From: Borg Belinda <bborg@penrithcity.nsw.gov.au>
Sent: Tuesday, 20 May 2014 1:46 PM
To: Pascal Van De Walle
Subject: Re: Email from Department of Planning in relation to TNT - Modification 1 SSD 6040 MOD 1 at Lot 201 DP 1...

We have reviewed the information and note the following amendments to the approved architectural plans:

DRAWING TITLE
SITE PLAN- OVERALL

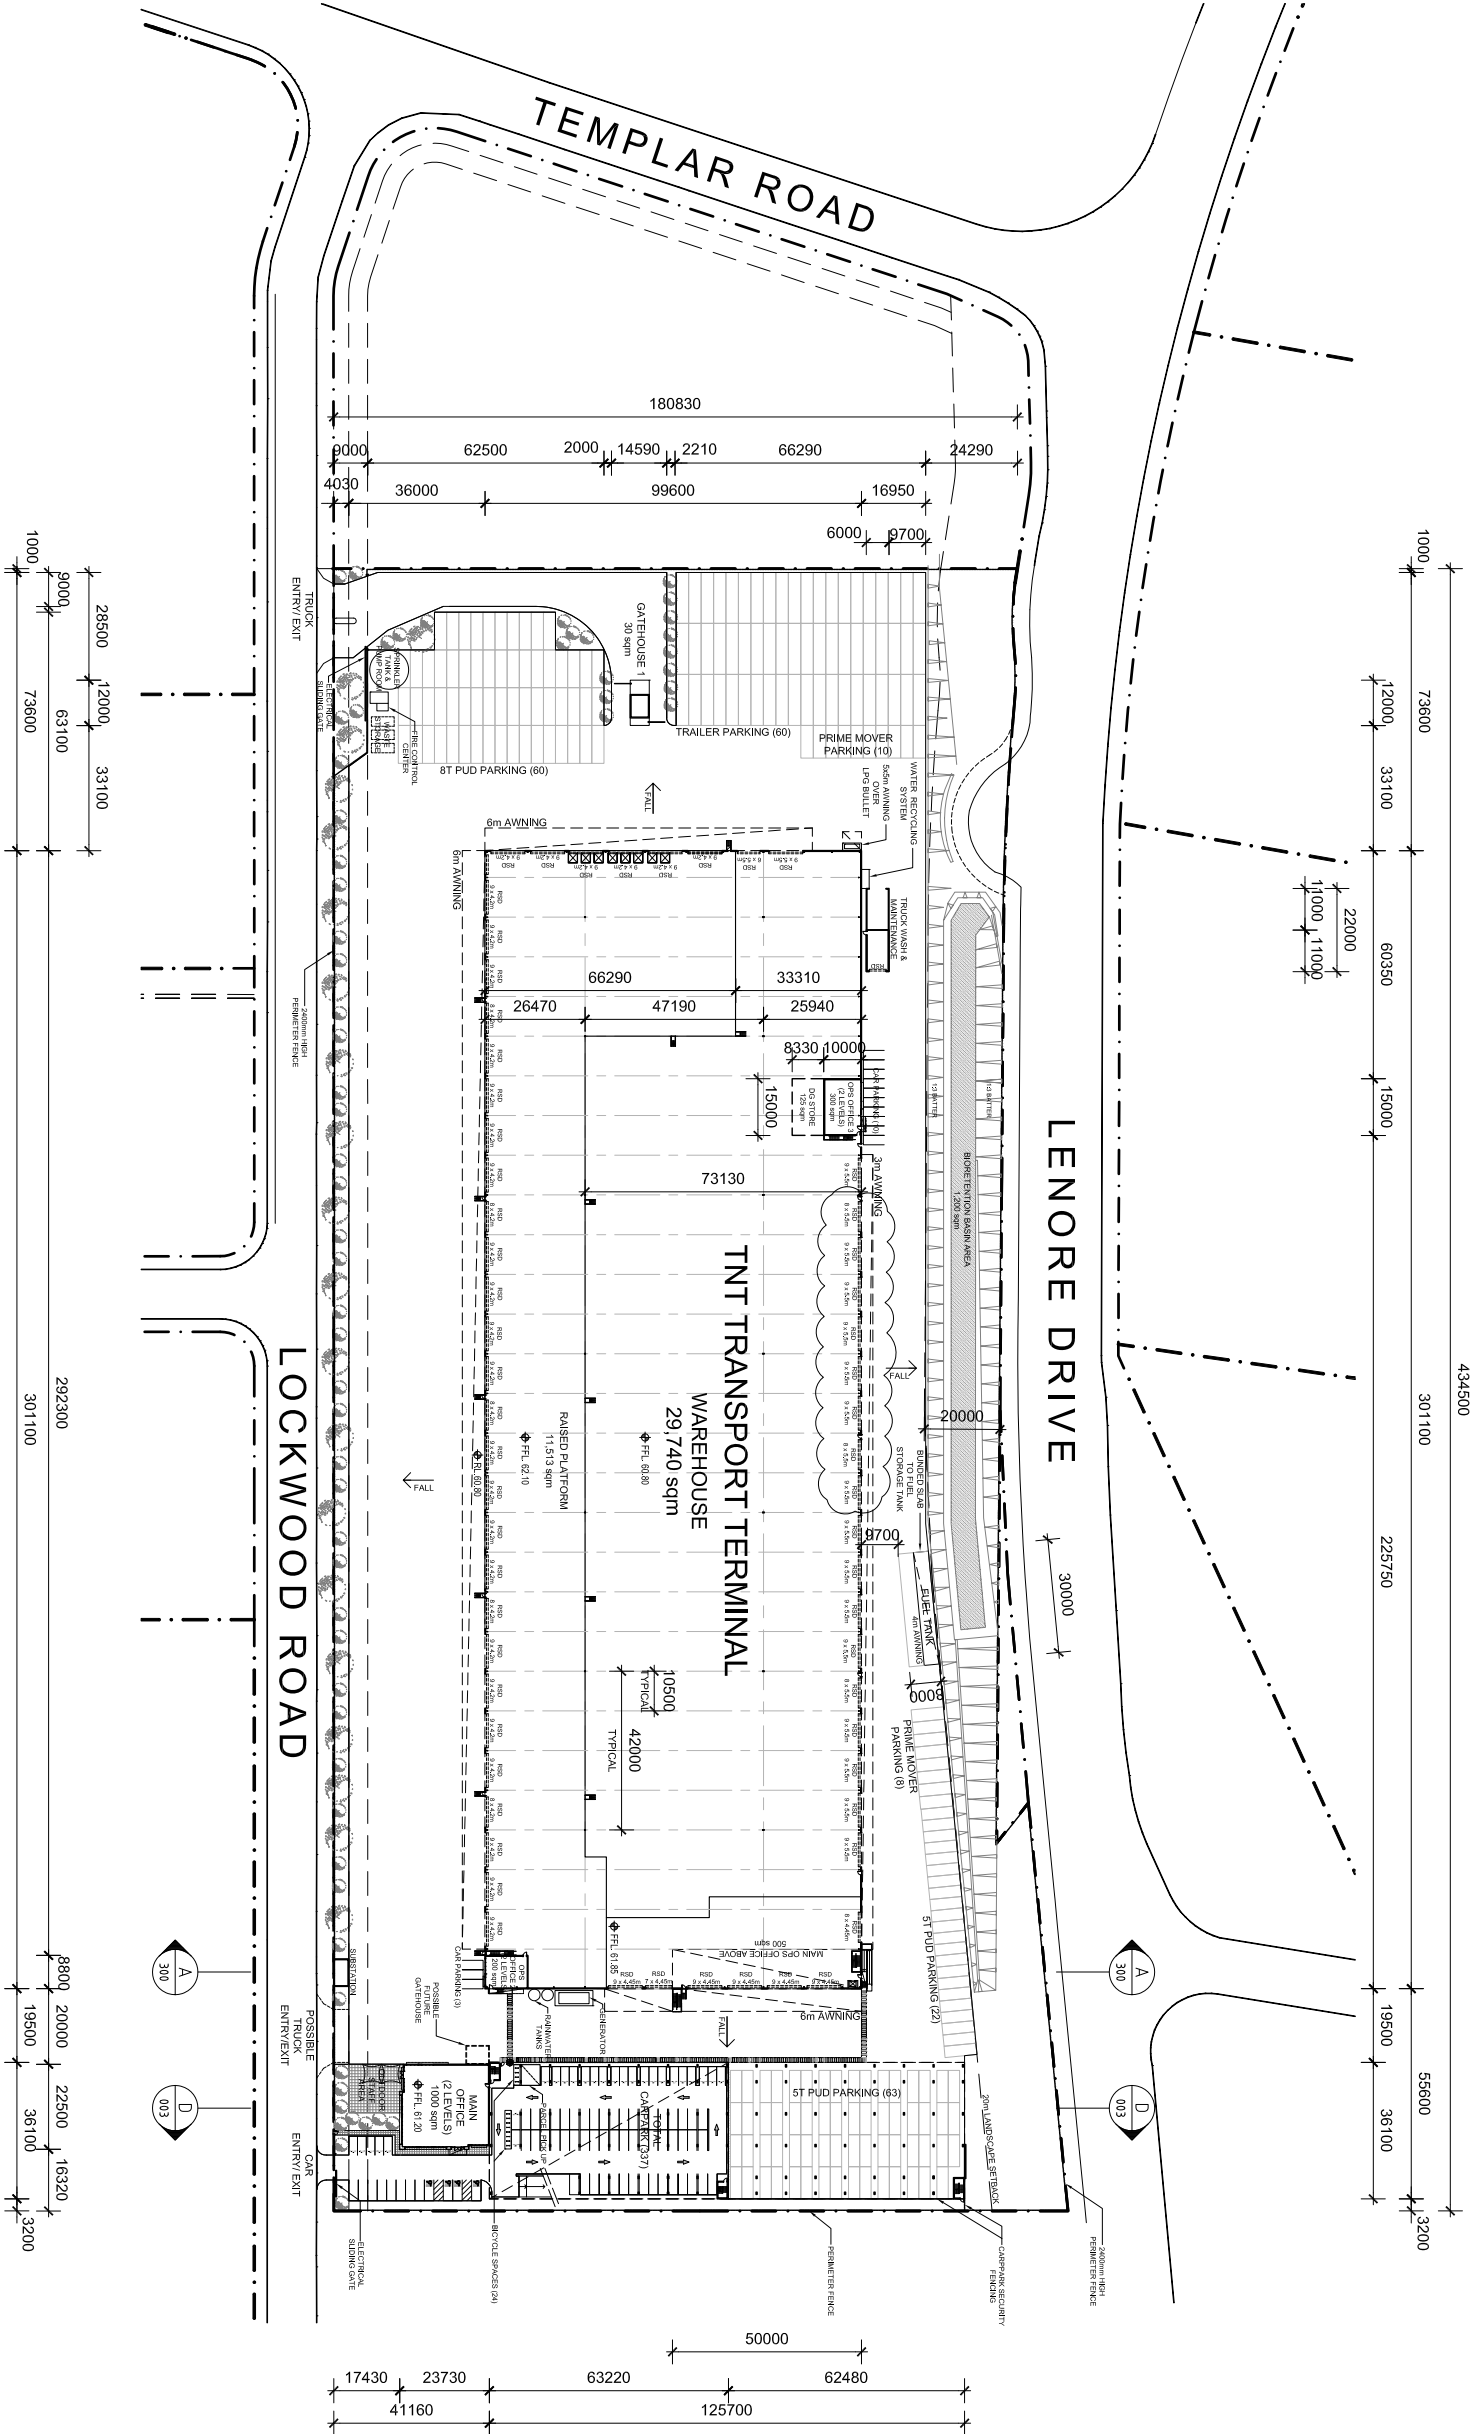
1. Relocation of the fire pump room;
2. Construction of 2 x 375,000L fire sprinkler tanks instead of 1 x 750,000L;
3. Construction of 2 x 1000 kVA substations instead of a single 1000 kVA substation;
4. Relocation of the main switch room from inside the building to the Lockwood Road frontage (behind the landscaped area);
5. Relocation of the electricity generator next to the main switch room (Lockwood Road frontage); and
6. Relocation of 6 parking spaces to create space for the 8 tonne pick-up and delivery trucks.

Council raises no objection to the modifications, subject to the provision of appropriate landscaping within the adjoining beds to the fire pump room and fire sprinkler ranks.
